WEST SUSSEX COUNTY COUNCIL CONSULTATION

TO:	Arun District Council FAO: Jessica Riches
FROM:	Stephen Gee WSCC – Highways Authority
DATE:	8 September 2025
LOCATION:	Land at Ford Airfield Ford
SUBJECT:	<p>F/14/24/RES</p> <p>Approval of reserved matters (layout, scale, appearance and landscaping) following outline consent F/4/20/OUT for the infrastructure RM including the provision of a primary spine road and associated secondary road junctions, pavement, footpaths, cycle infrastructure and bus stops; site wide drainage infrastructure including foul pumping stations, foul sewer infrastructure, SUDS basins, SUDS swales, surface water infrastructure; acoustic fencing; public open space including landscape details, play areas, footpaths & associated works. This application affects a Public Right of Way, may affect the setting of a Listed Building and falls within CIL Zone 1 (Ford strategic site - zero rated).</p> <p>More information received.</p>

DATE OF SITE VISIT:	n/a
RECOMMENDATION:	More Information

IRM - VEHICLE TRACKING AND
VISIBILITY PLAN (SHEET 3 OF 7)

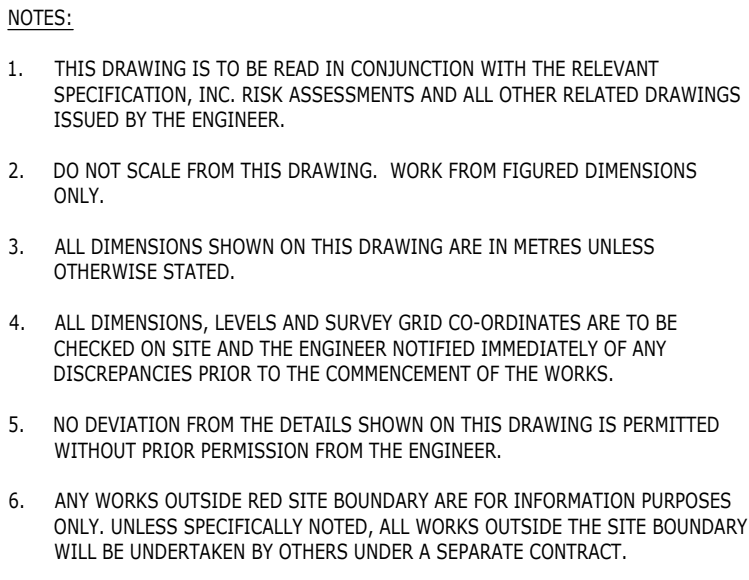
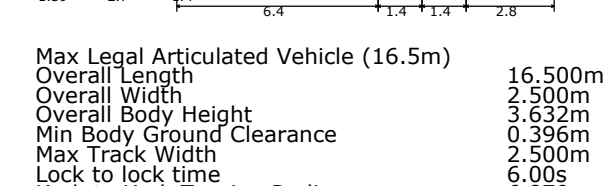
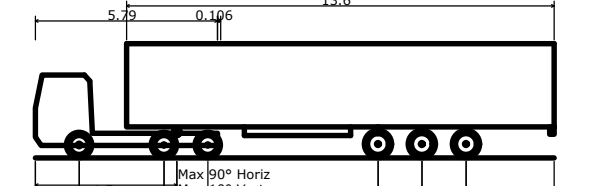
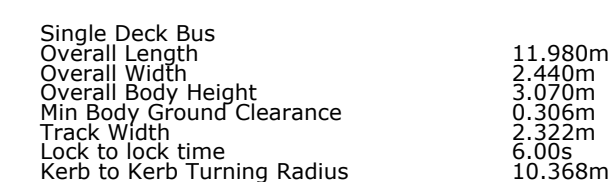
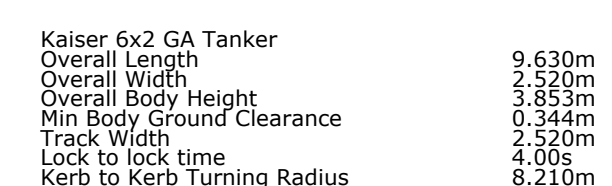
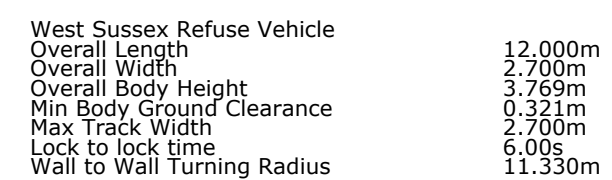
Can vehicle tracking showing the full movement onto and off the spine for the pumping station shown below be provided.
